Ref: **Cranford Agreement/Clarification of Details**
Date: **16 August 2013**

**CLARIFICATION OF ENVIRONMENTAL IMPACT ASSESSMENT INFORMATION
ENABLING WORKS FOR THE IMPLEMENTATION OF FULL RUNWAY ALTERNATION
(ENDING THE CRANFORD AGREEMENT)**

Title  
**CROSS SECTION B-B**

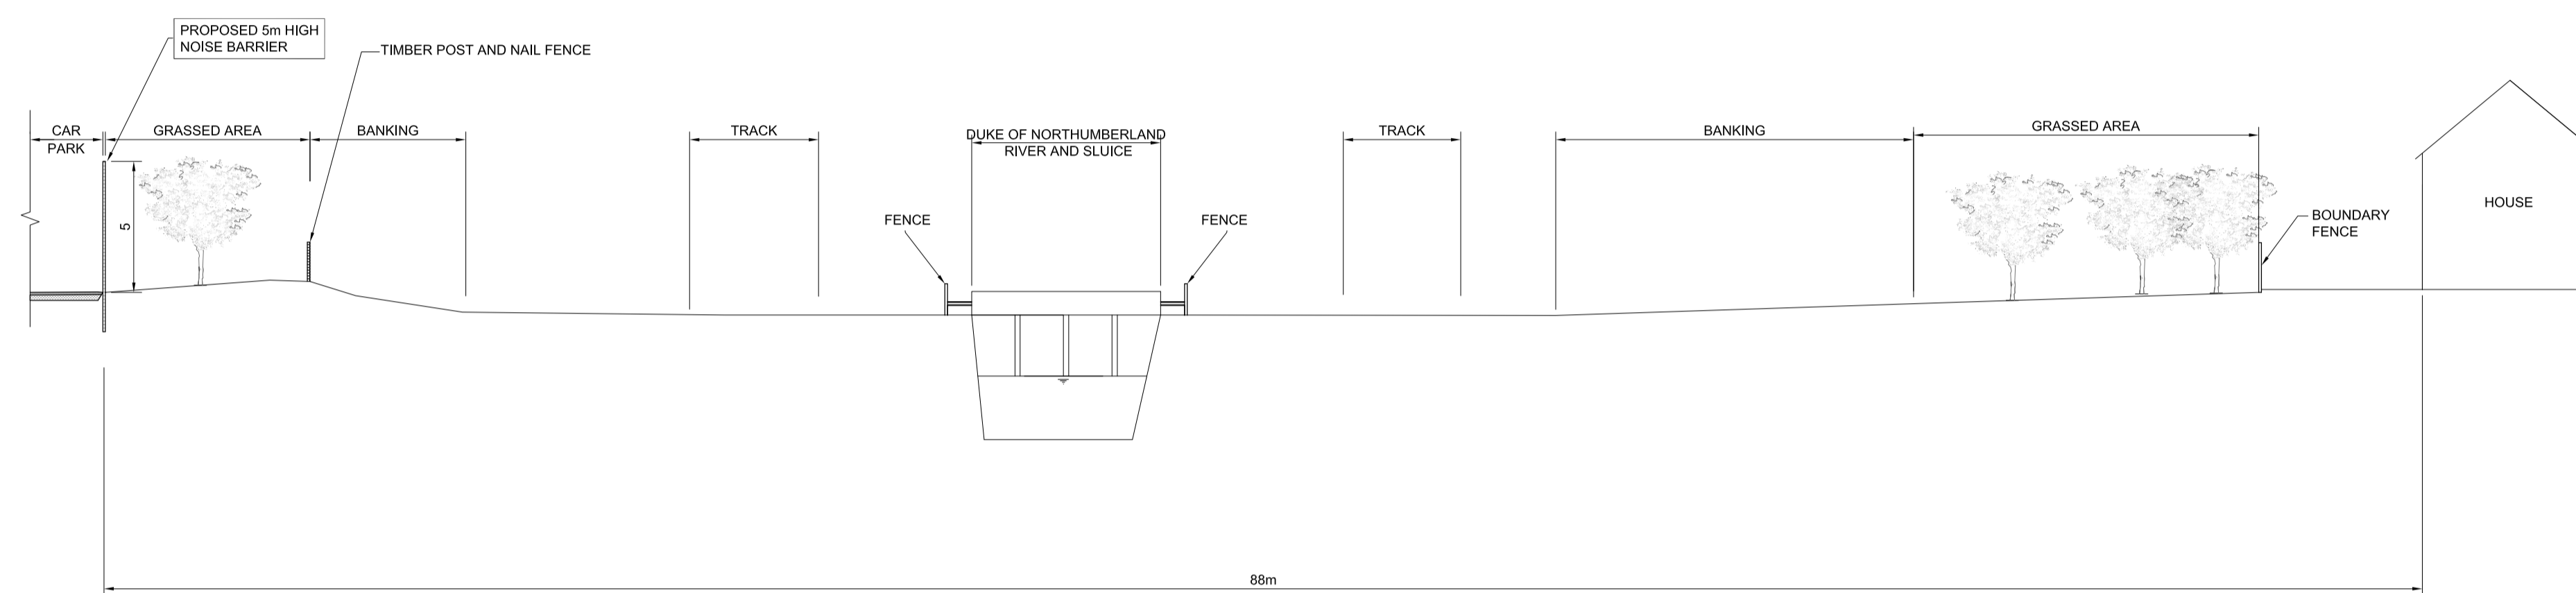
The text in paragraph 6.14.4 refers to the noise barrier and the mitigation to be provided in regard to reductions in noise.

3G Please could the evidence behind the assumptions of the noise reduction provided by the noise barrier be provided and the methodology for assessing the effect of the noise barrier be clarified.

The Council would appreciate further discussions about the noise barrier. The Council has requested a view point on many occasions showing the extent of the noise barrier from the airport side. This would provide a clear indication of the impacts of the barrier

across its length as opposed to just the viewpoints agreed previously on publicly available land. It is therefore not possible to fully consider the impacts on private residents without the presentation of any visuals showing the barrier in the context of the existing housing.

Furthermore, the Council does not believe it appropriate to have a single span of the same finishing. There are areas along the line of the barrier that would benefit from green screens (vegetation growing up a fence or barrier) as opposed to a transparent Perspex style finish.
